KITTITAS COUNTY DEPARTMENT OF PUBLIC WORKS

MEMORANDUM

TO: Dusty Pilkington, CDS
FROM: Kelly Bacon, Engineer Technician I *KB*
DATE: February 21, 2017
SUBJECT: Gibb BL-17-00003

SHEET 1 OF 2

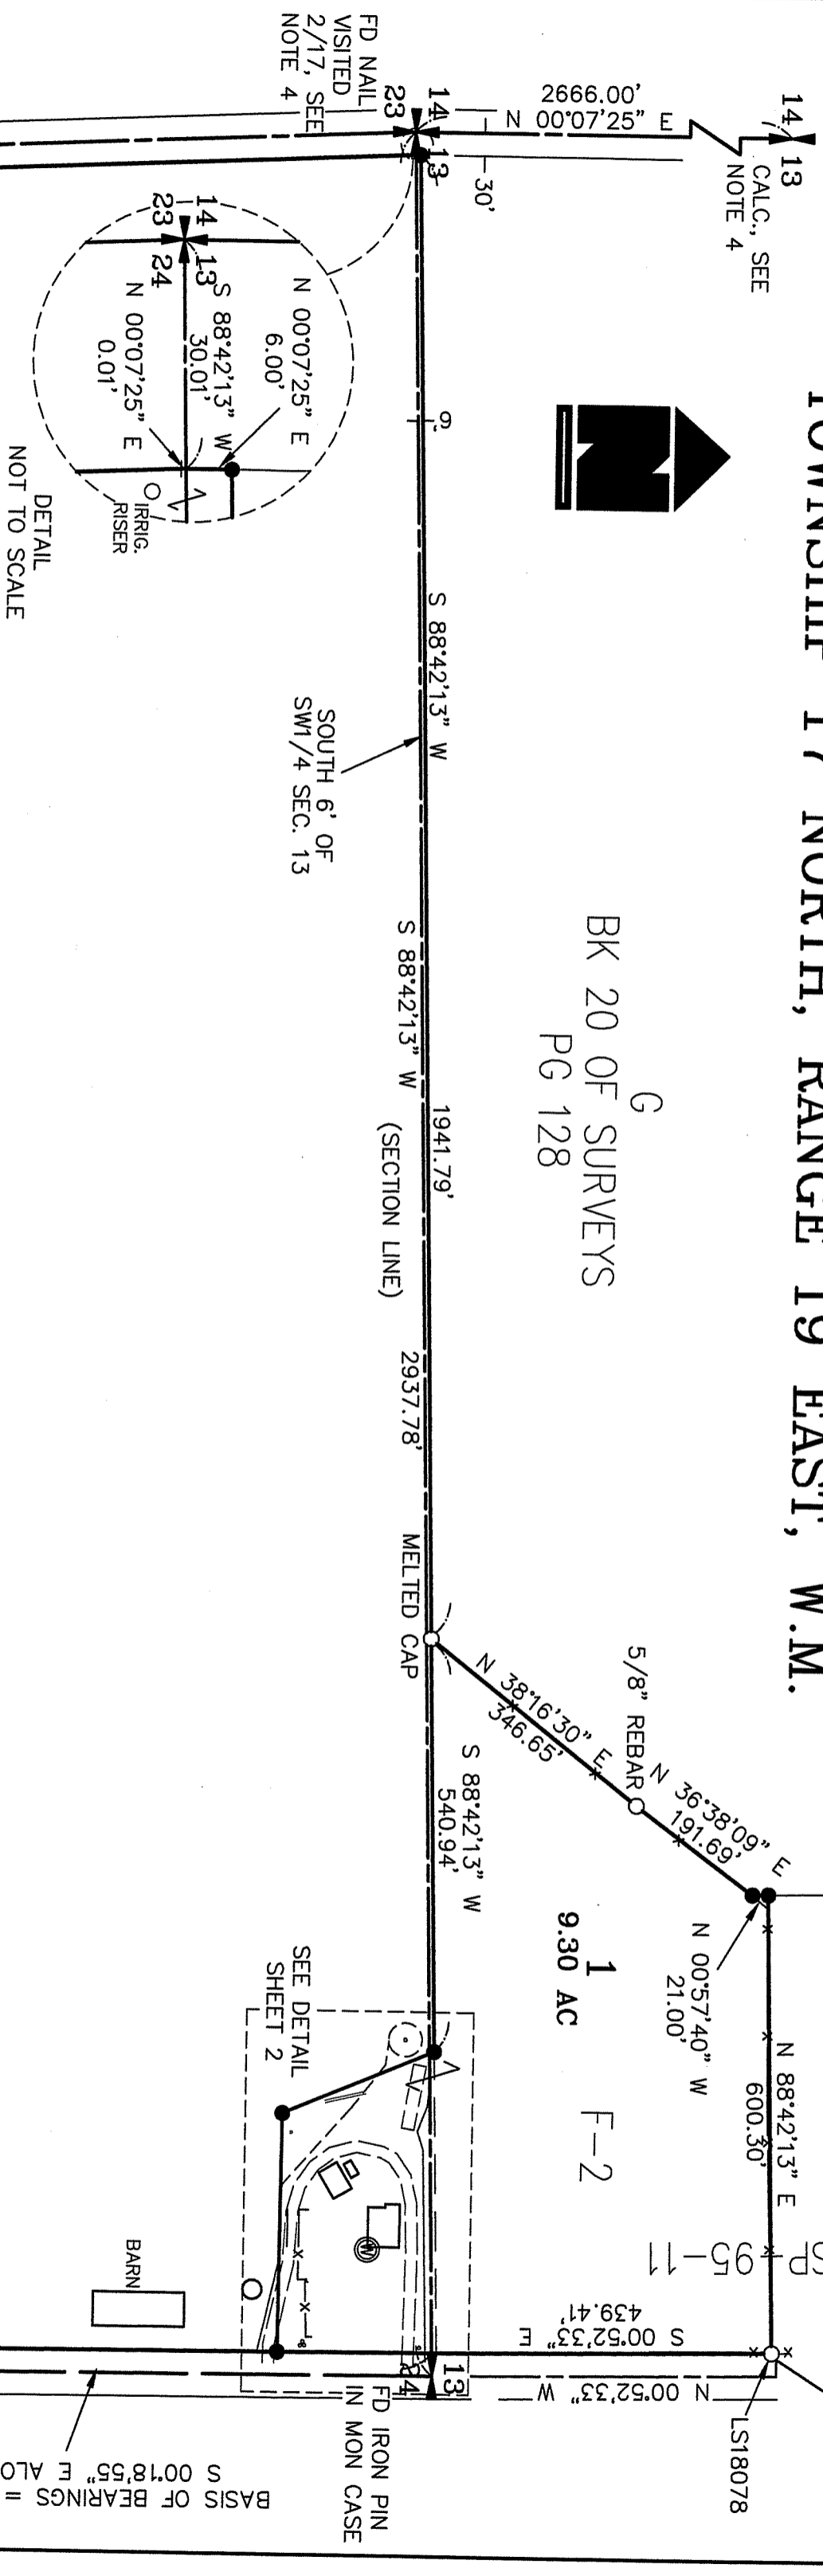
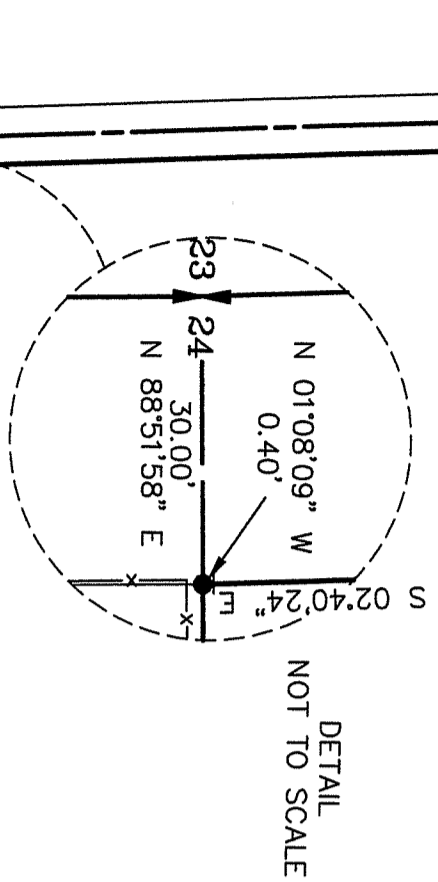
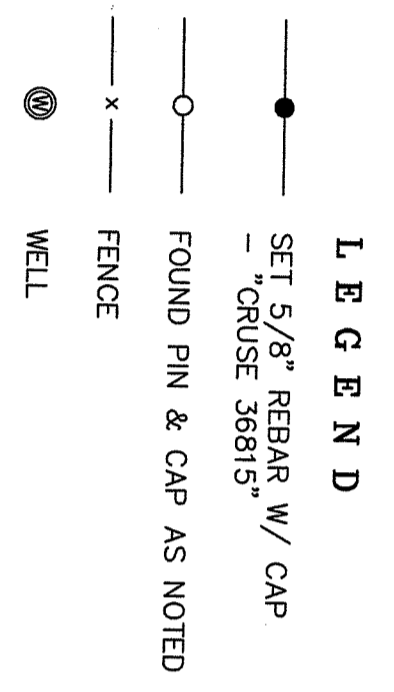
- a. Provide an access easement for the existing driveway across the northern portion of lot 2.
- b. An approved access permit shall be required from the Kittitas County Department of Public Works prior to creating any new driveway access or performing any work within the county road right of way.
- c. Maintenance of driveway approaches shall be the responsibility of the owner whose property they serve. The County will not maintain accesses.
- d. Any further subdivision or lots to be served by proposed access may result in further access requirements. See Kittitas County Road Standards.
- e. Evidence of existing access and/or evidence of access to be created should be confirmed prior to sale of property.
- f. Access is not guaranteed to any existing or created parcel on this application.
